MetroLink - Module 1

Witness Statement by [Brian Kavanagh of GARLAND] on Behalf of Charlemont & Dartmouth Community Group in relation to [Building Settlement]

This statement relates to building settlement and principally concerns impacts upon Dartmouth Road properties 26-28 and 32-35 and Dartmouth Square West nos. 1, 3, 5, 7, 9, 10, 11, 12, 13, 14, 15, 16.

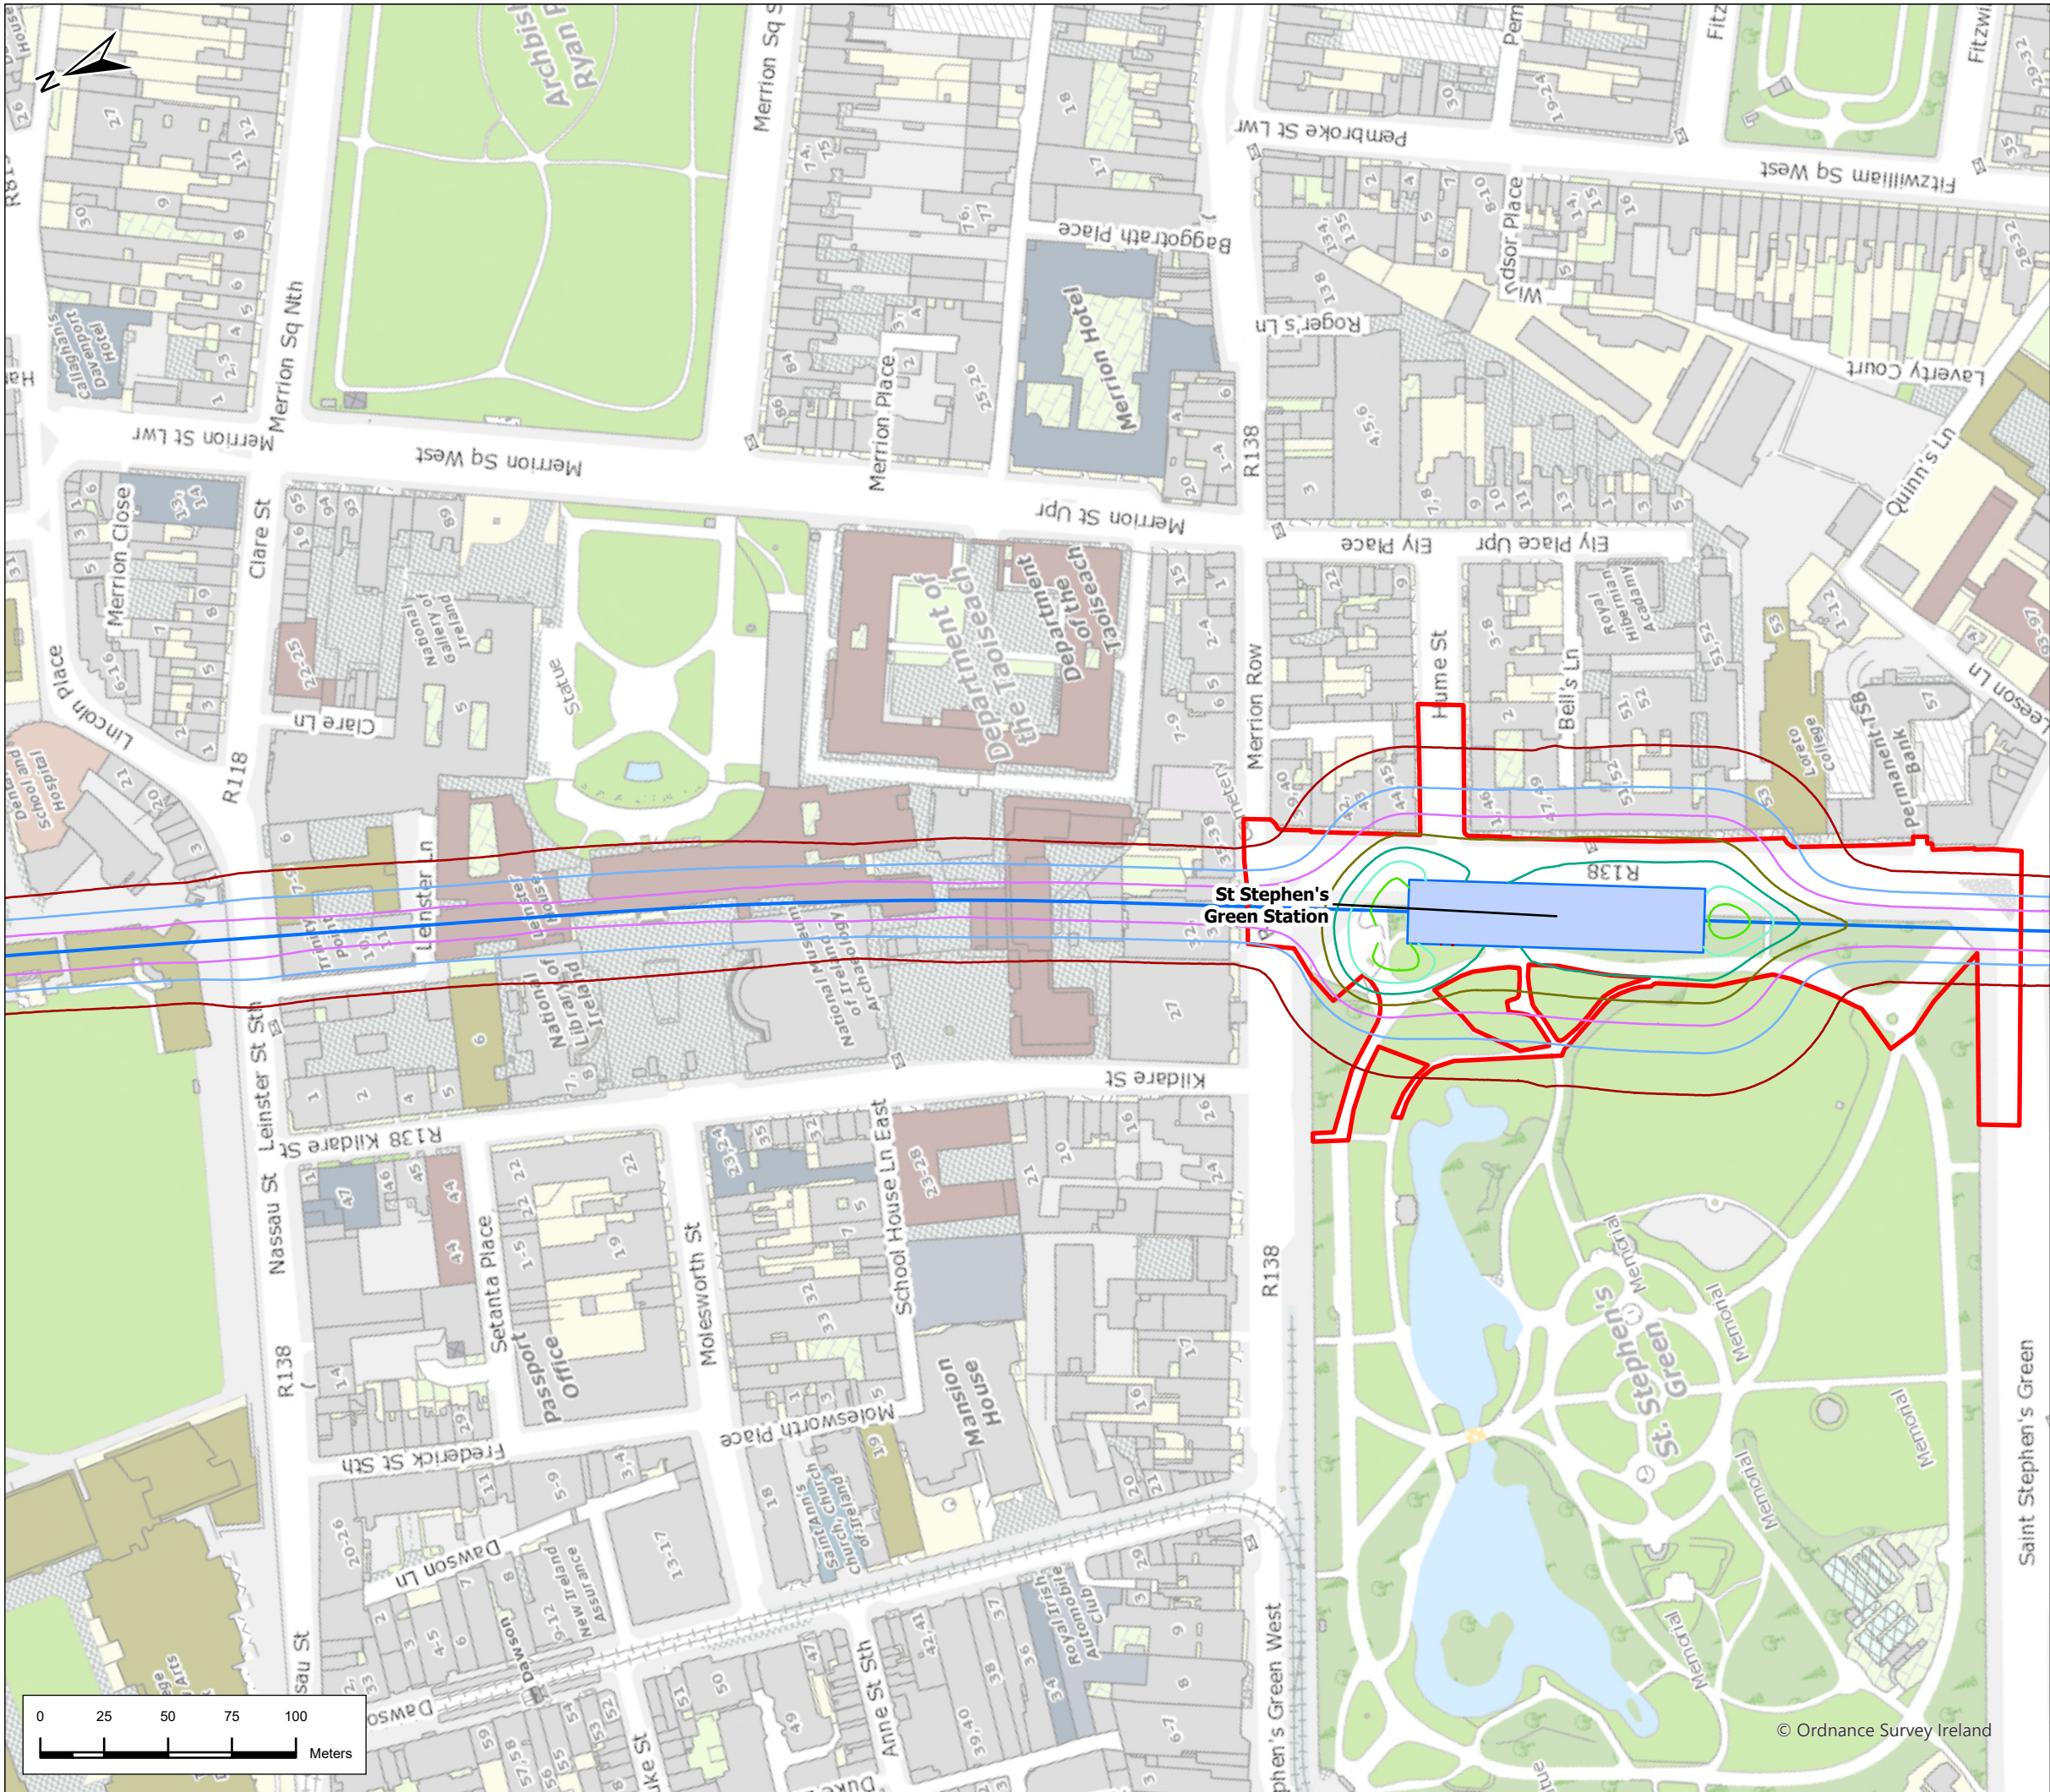
TII Building Damage Section (Appendix 5.19) has predicted “conservative” settlement figures in the area of the Charlemont Station / Turnback In the order of

30mm Rear of Dartmouth Walk / Square West

10mm Front of Dartmouth Walk / Square West

45mm Front of Dartmouth Road

35mm Rear of Dartmouth Road

However, these settlements are based on a “rectangular” station box. In fact, the actual extent of the station is considerably more, see extract from drawing below.

Nevertheless, the settlements which are noted above are differential settlements between the front and rear of masonry buildings dating from the mid-1800s. The impact of differential settlement on these tall, masonry buildings will be severe.

A review of the EIAR and associated appendices, it is evident that a very limited assessment of settlement and subsidence has been carried out. It can be seen from the above diagram that the houses directly over the tunnels on Dartmouth Road fall within the 35mm to 45mm settlement zone. This is defined as “slight” risk category. We would query this classification as “slight”. However, given that all but one of the buildings covered by this submission are protected structures, they should be classed as damage category risk 3 (moderate) or 4 (severe). We will discuss this later.
